**RE: COMMENTS FROM DRB HEARING - SKETCH PLAT 07/12/17
DRB PROJECT NUMBER 1002445- FOOT HILLS SHOPPING CENTER
PROJECT: SNOW HEIGHTS TR 1 & 2, BLK88**

Tierra West, LLC has addressed the comments from the DRB hearing for the Foothills Shopping Center which took place on July 17 2017 as follows:

Flood Note

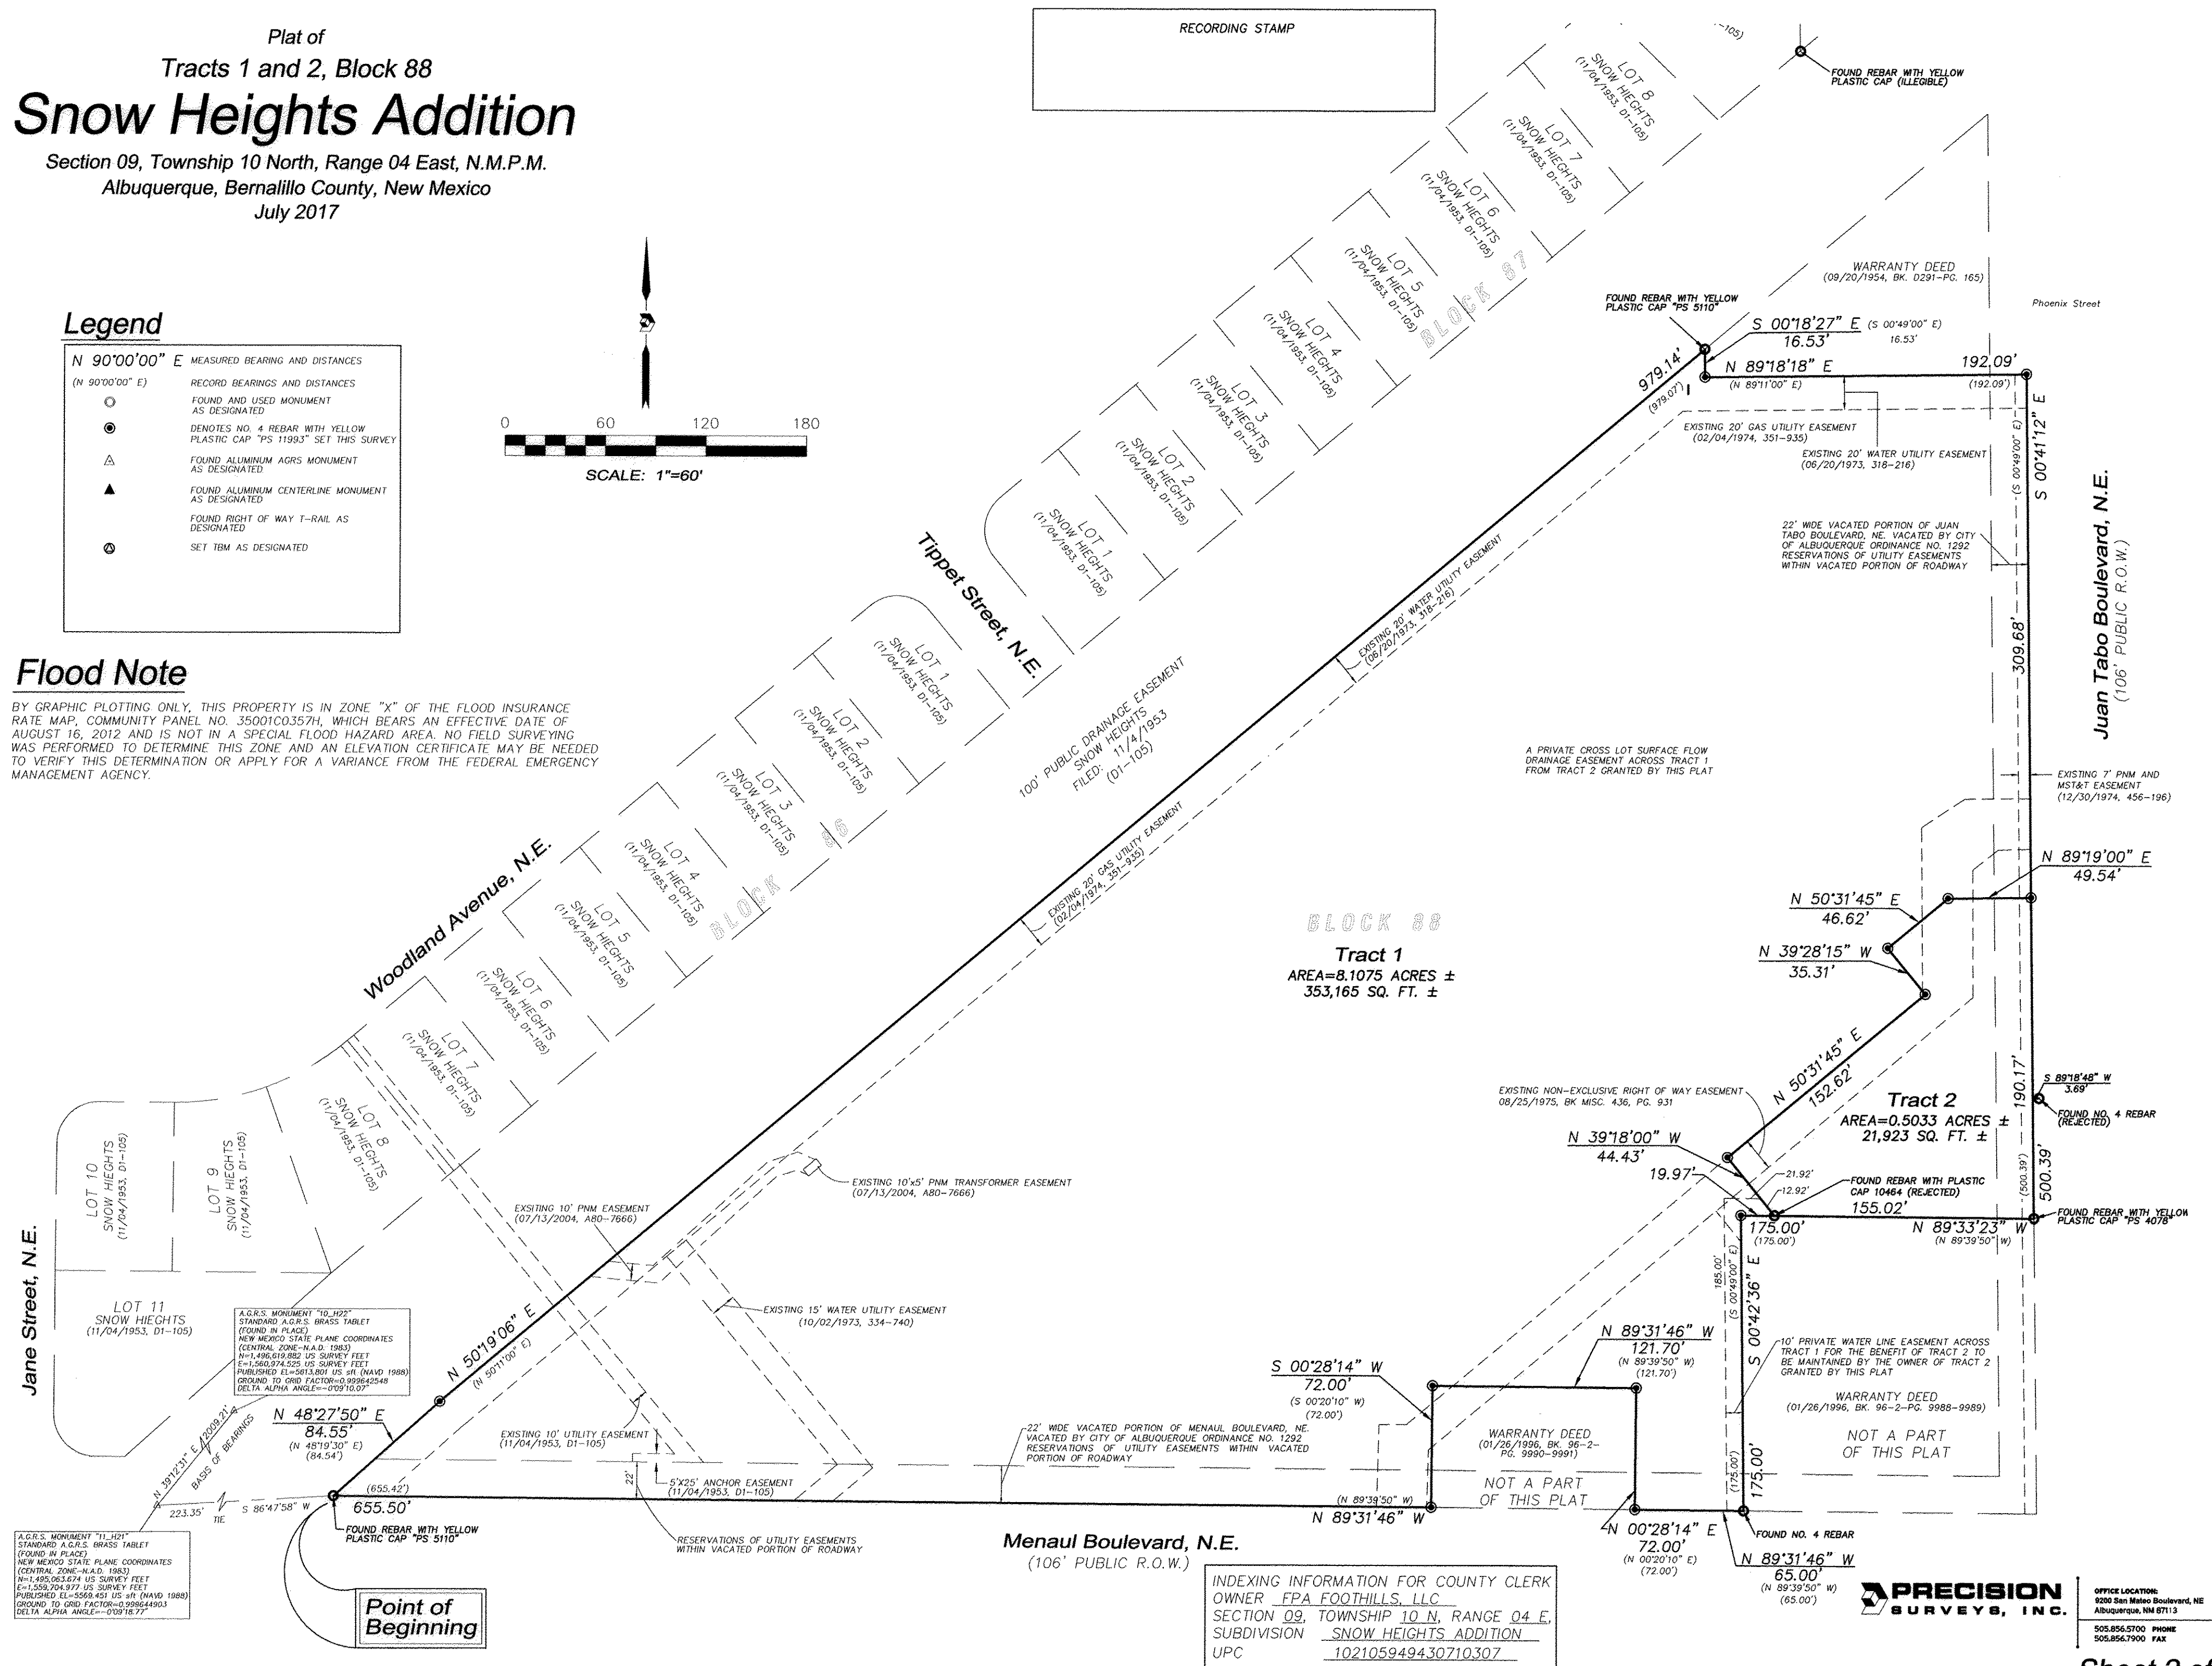
1. Add Flood Plain note & FIRM information (Zone X)
Response: The note has been added to the second page of the plat.
2. Cross-lot drainage easement is required (assuming scheme is to continue draining to the parking lot to the west.)

Response: A private cross lot drainage easement is shown on the plat on page two that allows drainage from new tracts across Tract 1.
3. An approved conceptual grading and drainage plan will be required for Site Plan or Site Plan Amendment

1. Future water and sanitary sewer service to development on proposed Tract 2 will require a request for a water and sanitary sewer availability statement.
Response: An easement has been shown on the approved Administrative Amendment and also shown on page two of the plat.
2. Consider granting a 10' private water easement across Tract 1 for the benefit of Tract 2 to permit access to water facilities in Menaul Blvd. There is no option for water service to Tract 2 from Juan Tabo Blvd.
Response: An easement is shown and granted on page 2 of the plat

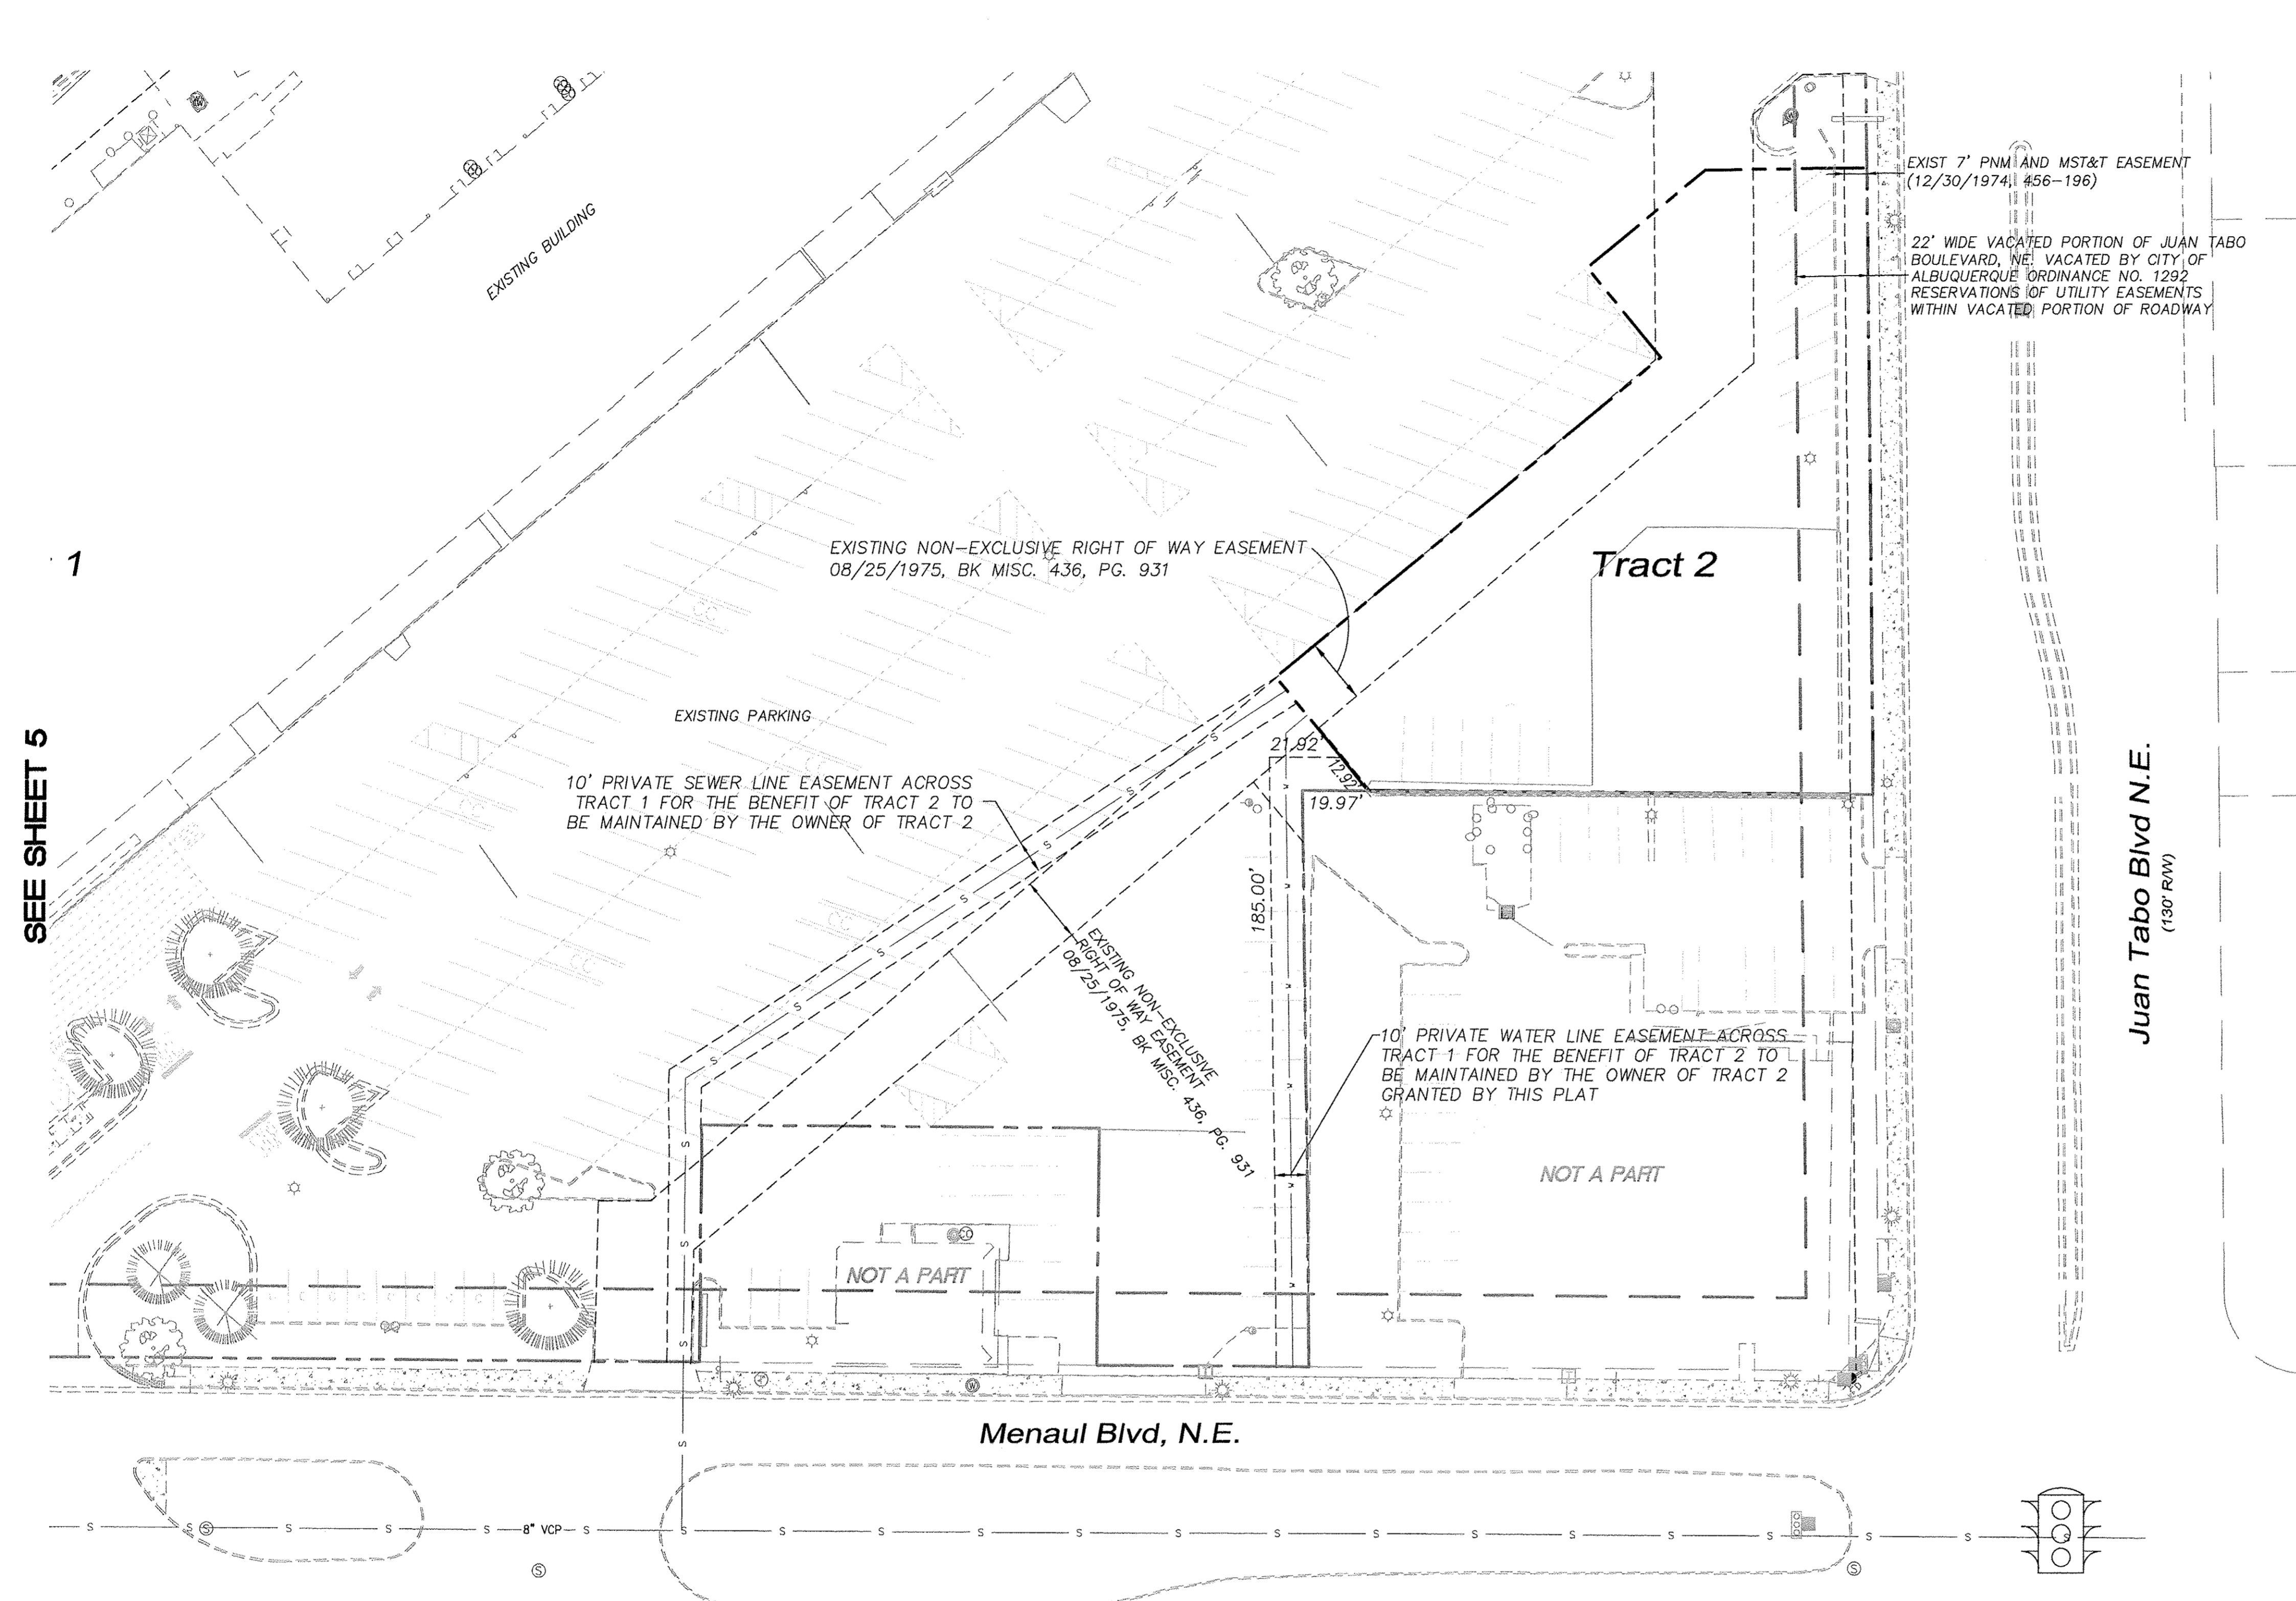
Response: A conceptual grading and drainage plan was included in the Administrative Amendment to the Site Development Plan which was approved on October 19, 2017. A separate copy of same is being submitted to the hydrology department along with this submittal.
